**Subject: Response to RW Gillespie & Associates Review of Gilman St. Temporary Support of Excavation Design Letter dated 1/21/21**

Subject: Geotechnical Engineering Review of Gilman Street Temporary Support of  
Excavation Design  
Maine Medical Center Hospital Expansion  
Portland, Maine  
RWG&A Project No. 0557-031

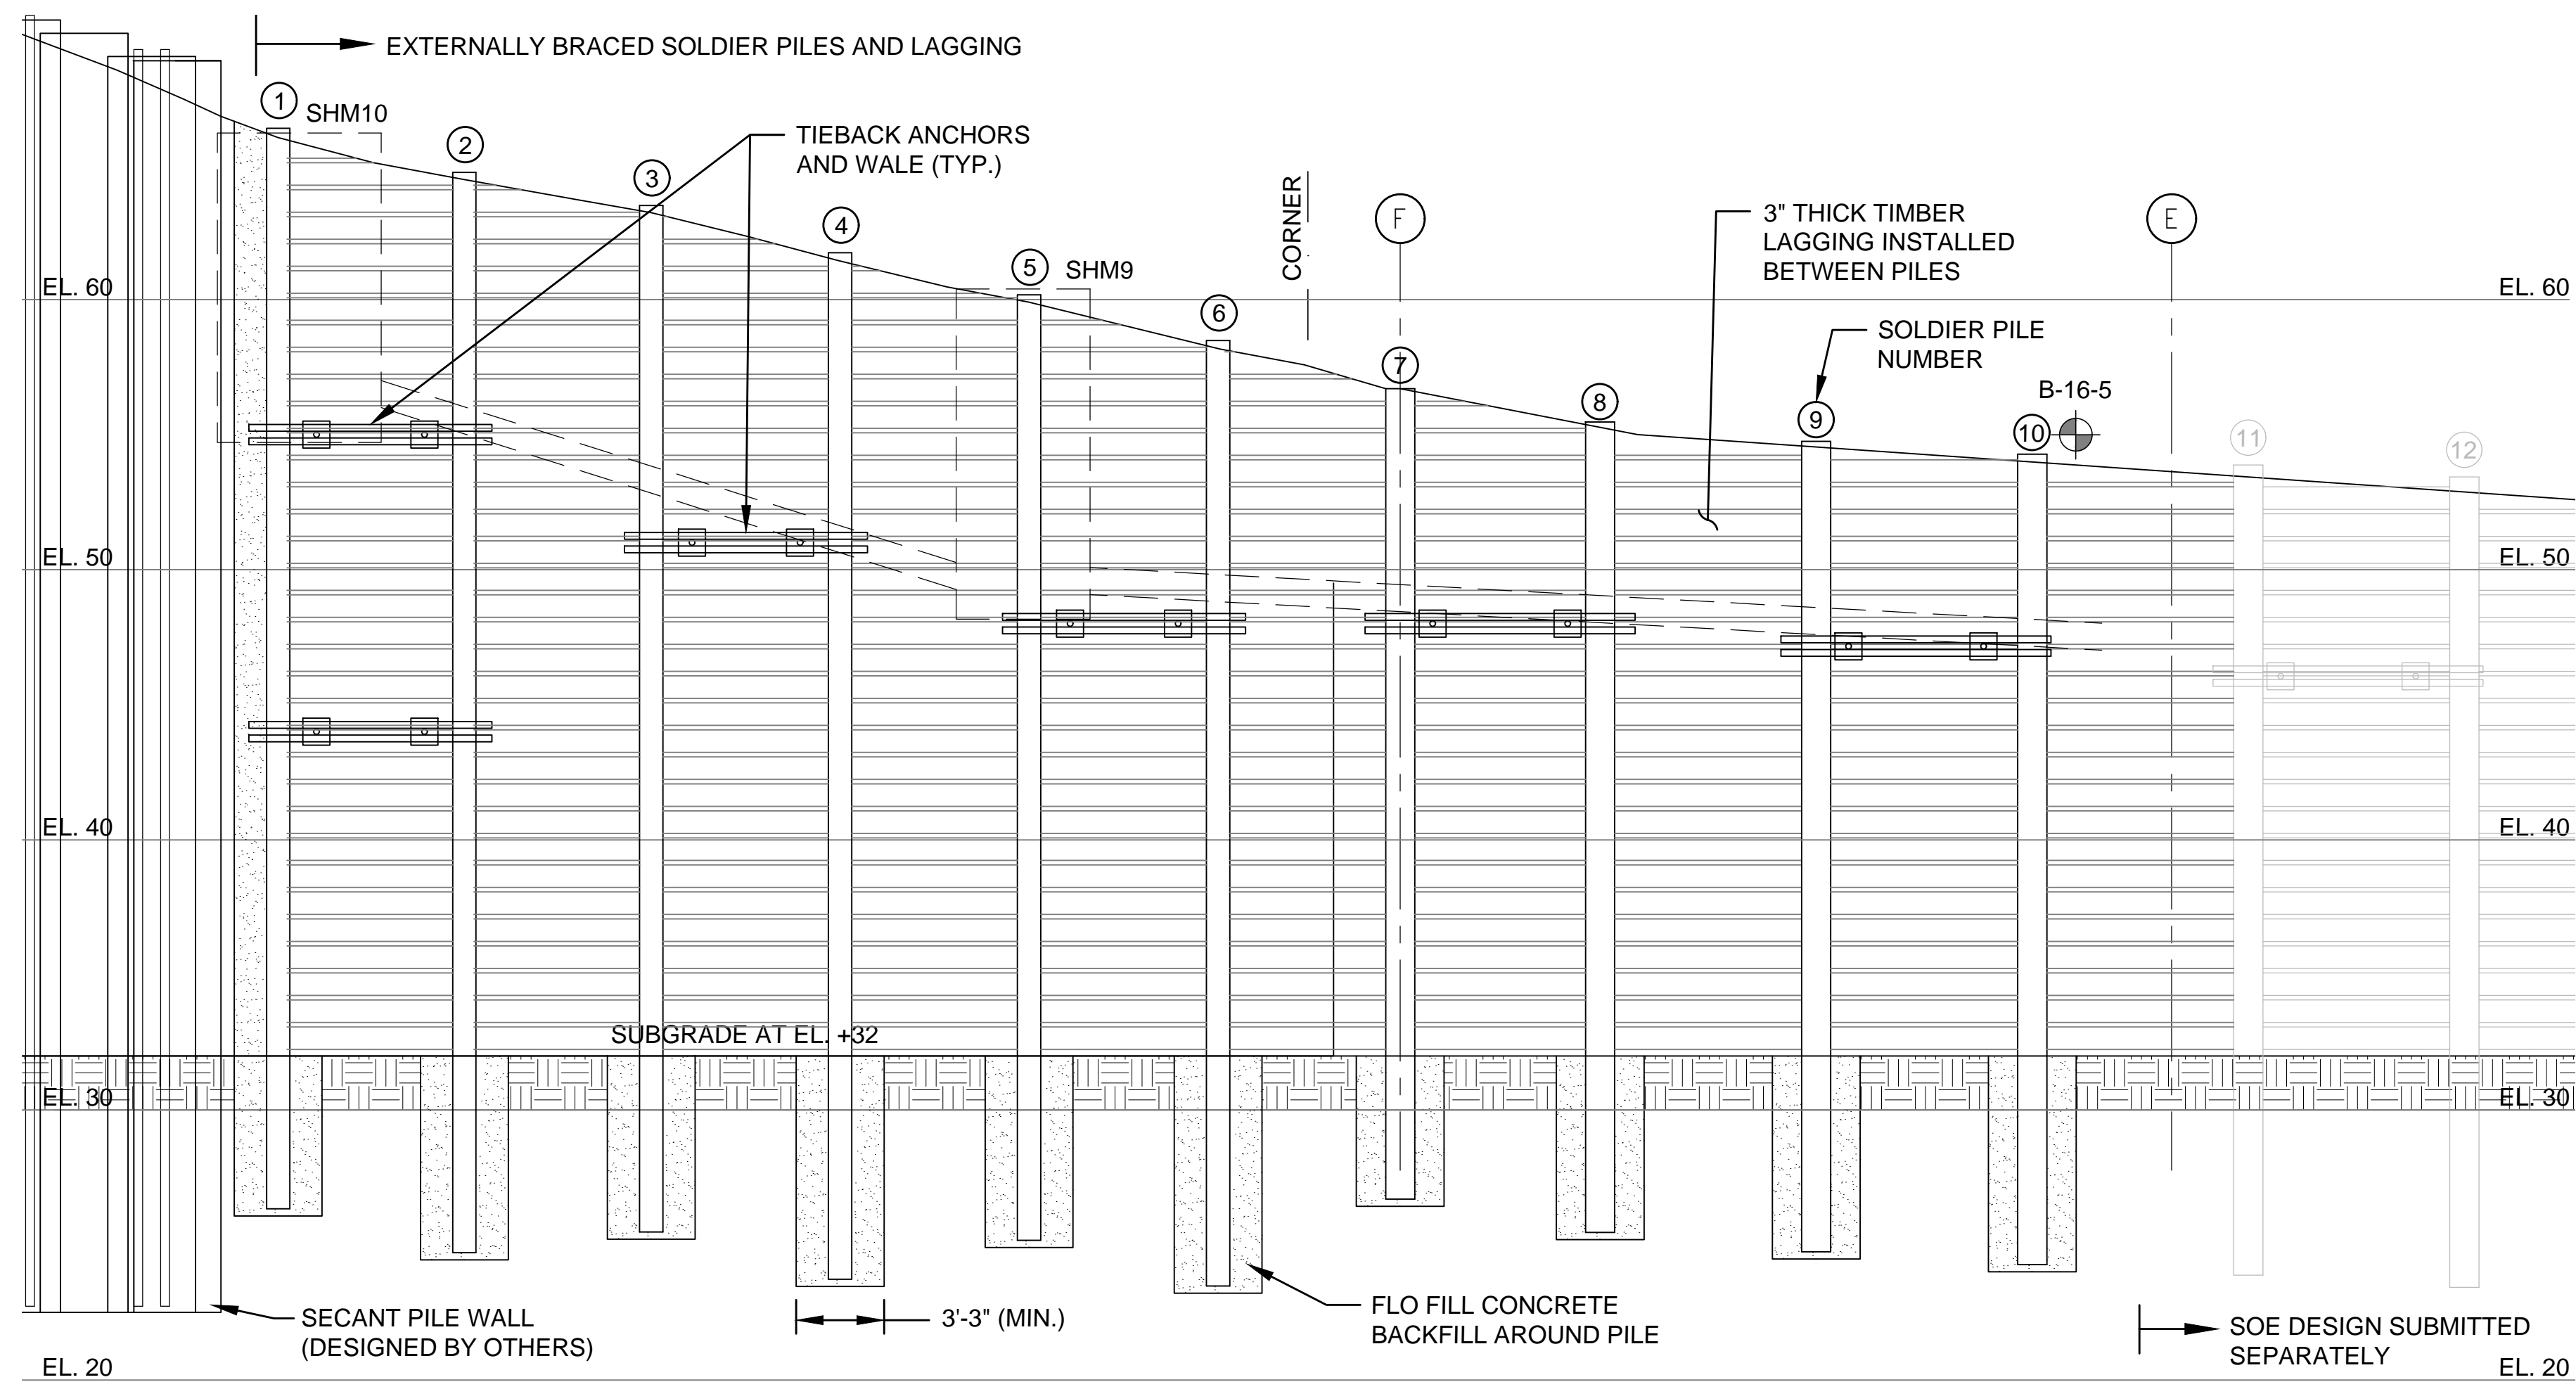
**Comment:** *RWG&A suggests that the designer describe the range of anticipated settlements and expected variation with distance behind the excavation. This information would help assess and compare construction monitoring data to anticipated movements.*

**Comment:** *RWG&A recommends that horizontal and vertical surveys abandoned tieback and soldier pile information be conducted with the results of the surveys provided to the City.*

*Comment:* MMC should affirm that survey, construction, and design modifications are in place to assure that the tieback system will not extend beyond the westerly right-of-way boundary. The contractor should indicate how location, length, and angle control will be maintained and verified during installation.

**Response:** **SGH - Based on the estimate of anticipated settlements behind the permanent SOE, we estimate up to 0.5 in. of lateral and vertical movement behind the southwest corner temporary SOE. We estimate movements would reduce to zero within 30 to 45 ft. behind the wall.**

**Response:** Turner will provide an as built of the installed soldier piles and tiebacks for record and provide a copy to the city upon completion of foundation work.

**Response:** Keller - We will fabricate the tiebacks on site to the exact lengths as show in the design submittal drawings. The verticality / batter angle of the drill hole will be monitored by the use of a digital angle gauge which has a + - 0.2 degree angle accuracy which will be attached to the mast of the drill rig.
